TfNSW Reference: SYD21/00232/06

DPIE Reference: SSD-15221509

**EXHIBITION OF EIS - WOOLWORTHS WAREHOUSE & DISTRIBUTION CENTRE
250 VICTORIA STREET, WETHERILL PARK**

Attachment A

B14

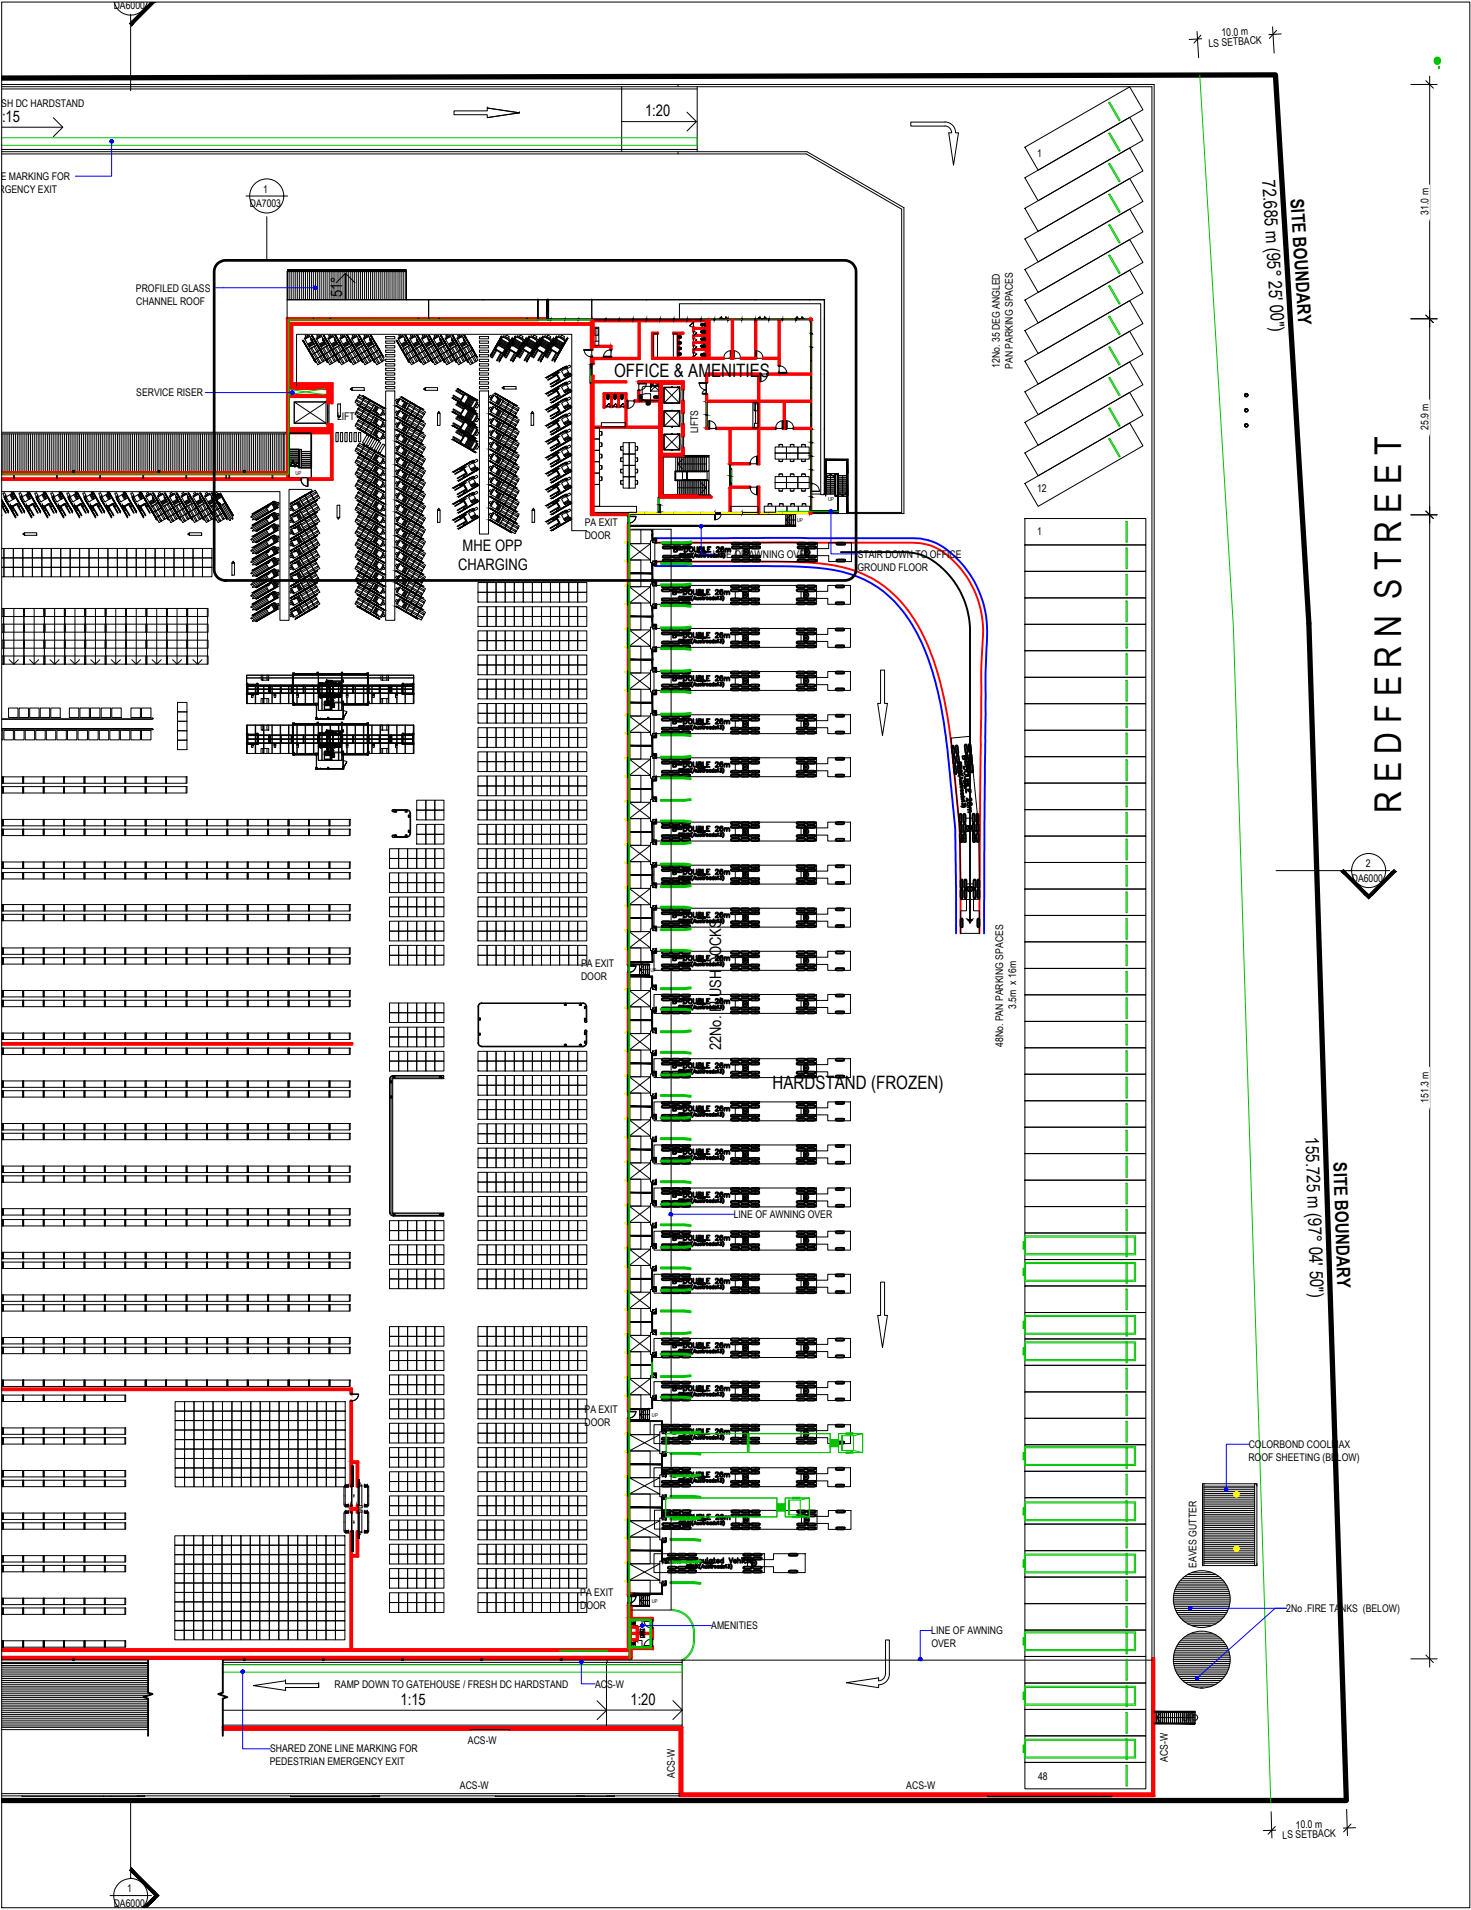
Swept path analysis should be provided for the longest vehicle accessing the site from Victoria Street and demonstrate how simultaneous entry/exit can be achieved at the proposed access.

- Confirmation whether the anticipated number of truck movements generated by the proposal made any assumptions on the use of Higher Mass Limit (HML) vehicles. Both Redfern and Walter Streets are currently not approved for HML short combination nor HML B-Double access.
- Confirmation whether there are any proposed boom gates or access gates for heavy vehicles entering the site as this could potentially cause queuing of heavy vehicles onto Redfern Street.
- Confirmation whether B-double decoupling areas are needed so that both the 'A' and 'B' trailers can be unloaded from the rear. The swept path diagrams show the full B-double combination approaching and departing the loading docks.
